**GEOTECHNICAL INVESTIGATION
MAYBERRY APARTMENTS AND TOWNHOMES
TRACT K
STATE HIGHWAY 94 AND NEW LOG ROAD
ELLICOTT, COLORADO**

CTL|T Project No. CS19587-125

September 9, 2022

VICINITY MAP
(NOT TO SCALE)

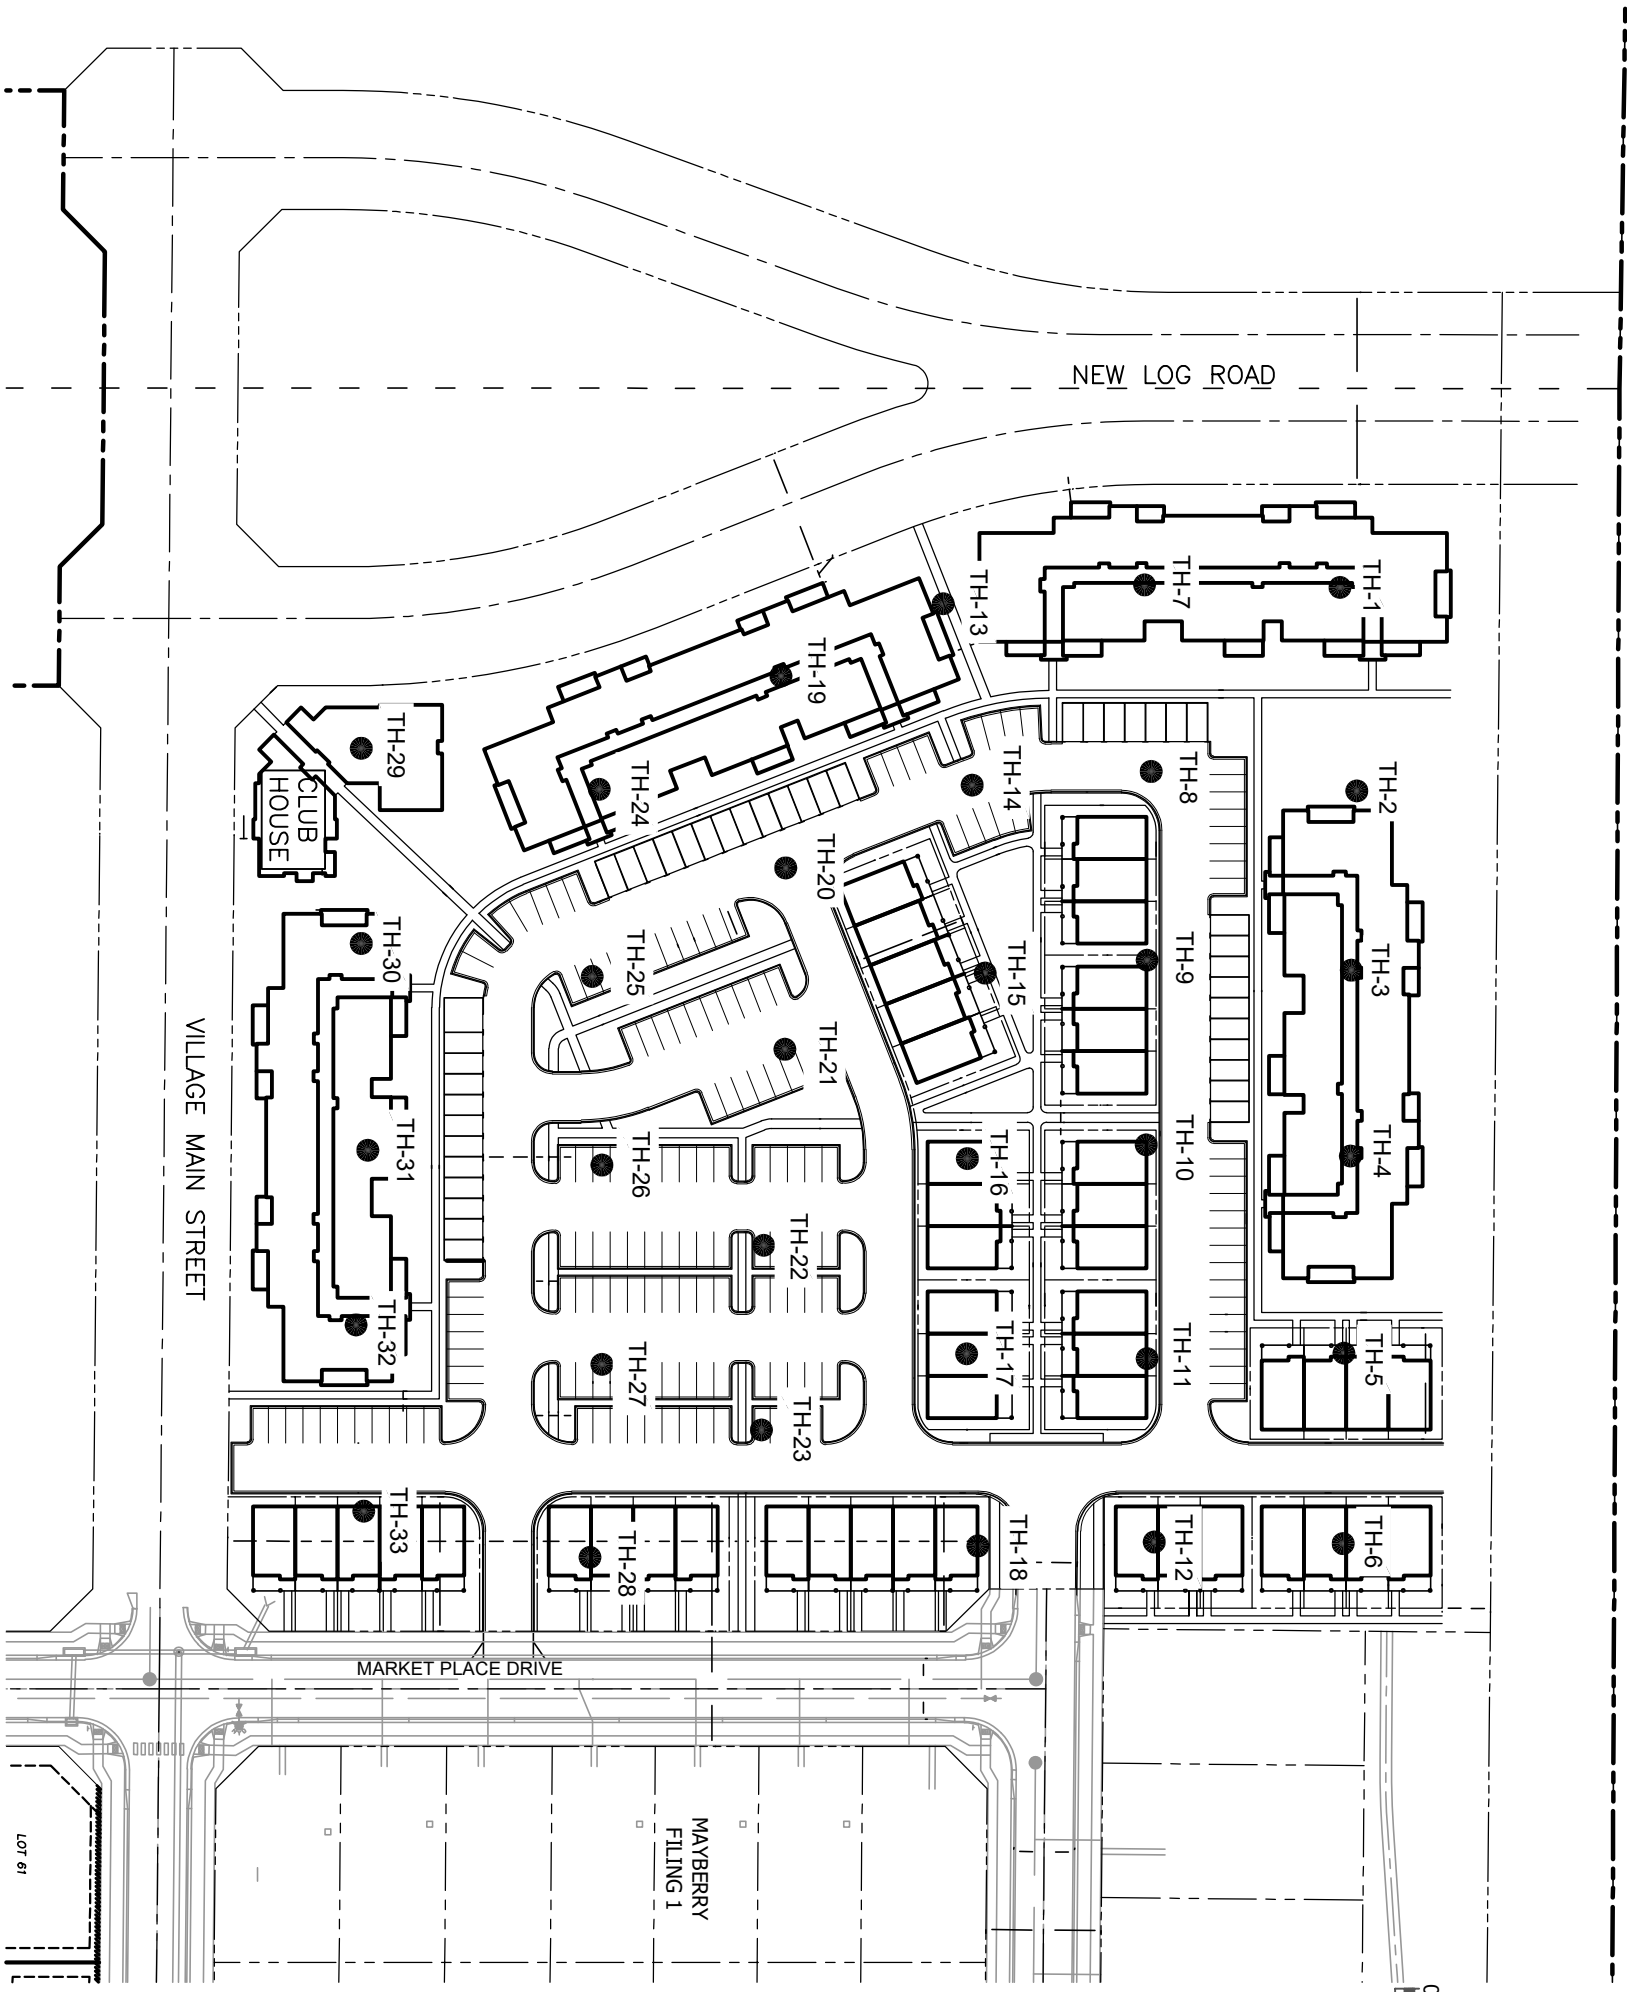
Please review the soils & geology report checklist for report requirements. A detailed map, drawn to scale, is required for all soils & geology reports. The checklist details the required information to be included on the map.

Geologic hazards and constraints need to be identified and shown on the map, and also reflected in the soils & geology note on the PUD plan and depicted on the development plan.
